**KIRKLEES METROPOLITAN COUNCIL
INVESTMENT & REGENERATION SERVICE**

**DELEGATED DECISION FOR DISCHARGE OF CONDITION A.4 -
NOTIFICATION OF A PROPOSED ENLARGEMENT TO DWELLINGHOUSE**

Reference no.	2025/HH/92875/E
Site Address	Squirrel Lodge, 19, Liversedge Hall Lane, Liversedge, WF15 7DP
Description	The proposal is for erection of single storey rear extension. The extension projects 8m beyond the rear wall of the original dwellinghouse. The maximum height of the extension is 4m, the height of the eaves of the extension is 3m
Recommending Officer	Joanna Rednall

DECISION - REFUSED

Issue Purpose : HH Application		
Project	Proposed Single storey rear extension	Date 14-10-2025
		Scale 1:250 @ A3
Address	Squirrel Lodge, 19 Liversedge Hall Lane, Liversedge, WF15 7DP	Site plans
		D.N. 2025 - 19LHL - 02

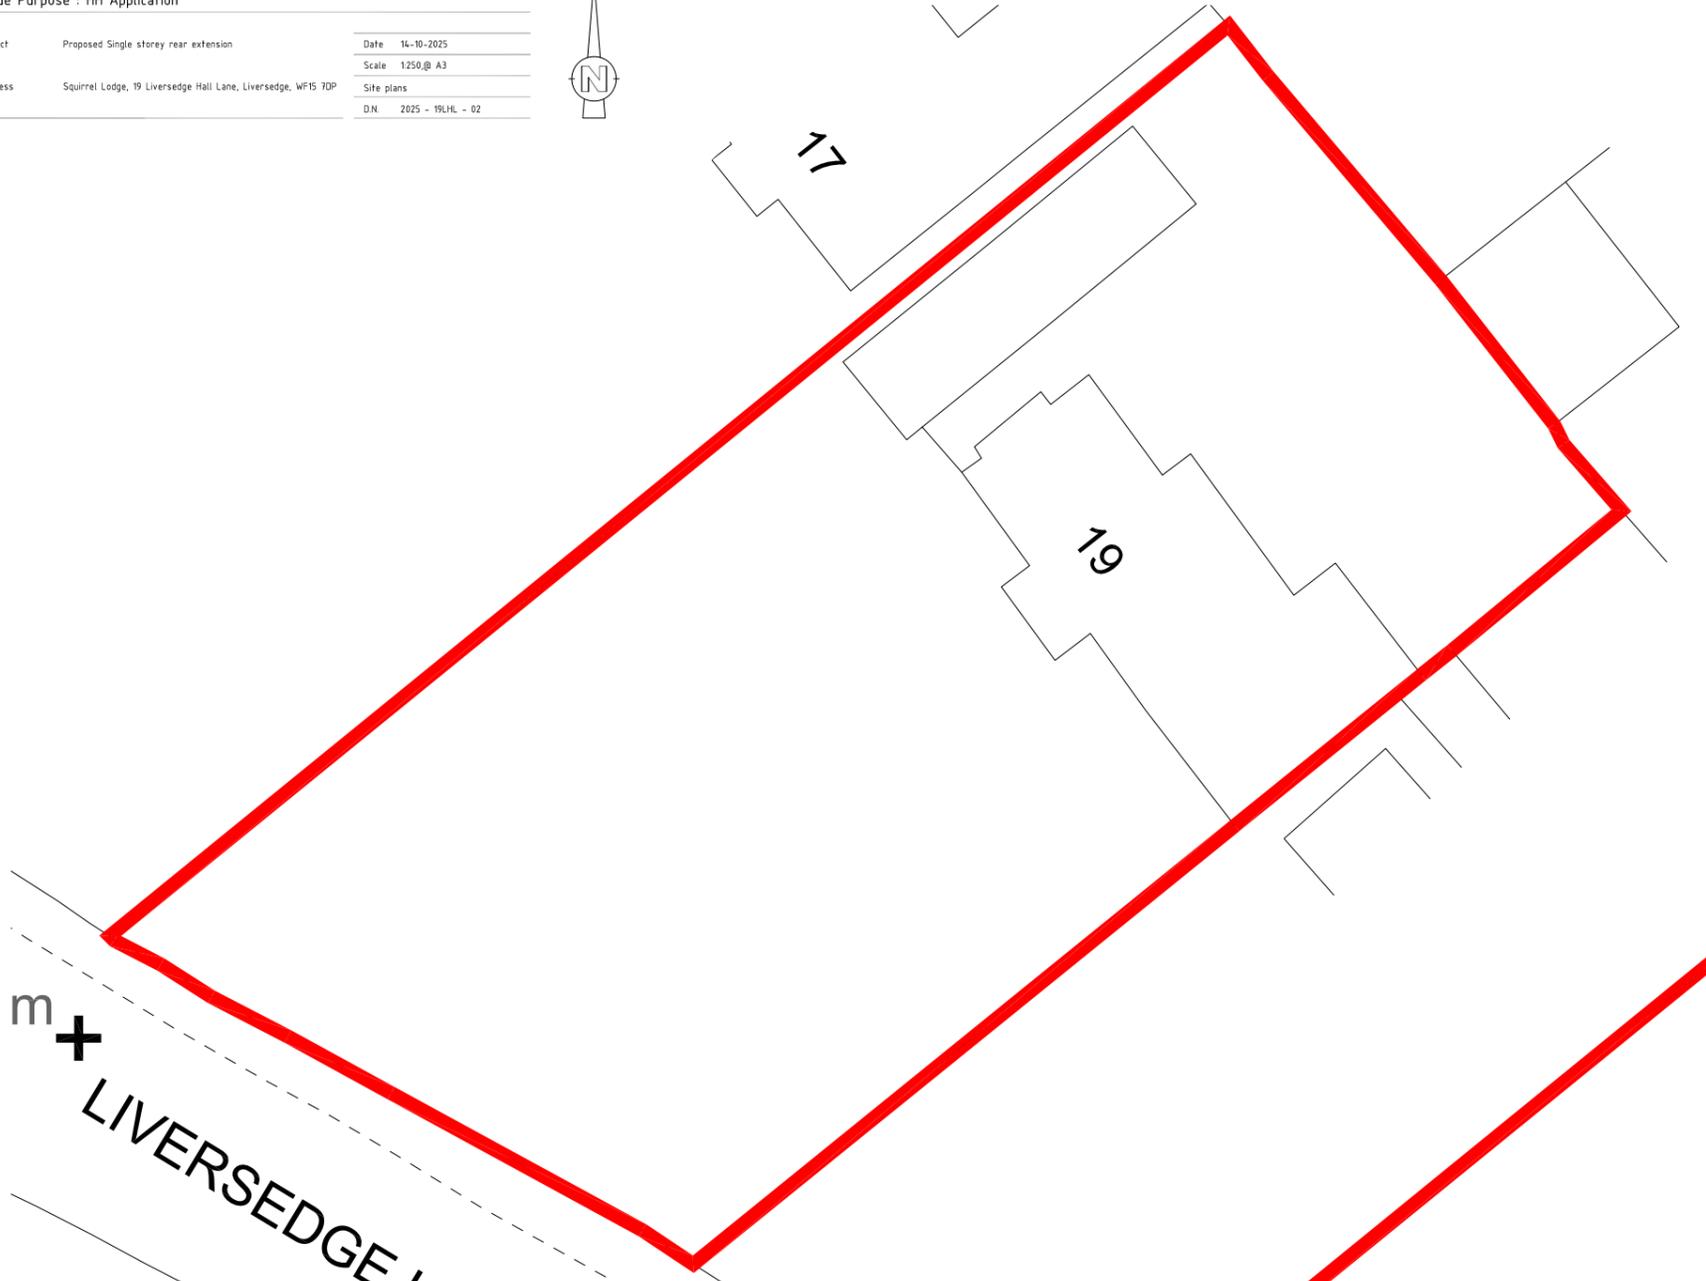
This rearward projection appears consistently on the historic maps dated 1955 and 1965, indicating that it is an original side elevation of the dwellinghouse. The proposed enlargement also adjoins an existing side enlargement to the original dwellinghouse. The combined enlargement clearly projects beyond the side south east elevation of the original dwellinghouse. The proposed extension measures 10.5 m in width across the rear elevation and would extend beyond this side elevation. The width of the original dwellinghouse measures 15.5 m.

Officers therefore consider the side of the original projection to form a side elevation of the original dwellinghouse and to be an original feature. As a result, the proposed extension would extend beyond this point with a width greater than half the width of the original dwellinghouse.

Therefore, the proposed enlargement cannot benefit from a general planning permission under Article 3(1) and Schedule 2, Part 1, Class A of the Town and Country Planning (General Permitted Development) (England) Order 2015 (as amended), Schedule 2, Part 1, Class A as the enlarged part of the dwellinghouse would extend beyond walls forming a side elevations of the original dwellinghouse and would have a width greater than half the width of the original dwellinghouse contrary to sub-paragraph A.1(j) & A.1(ja) of Class A.
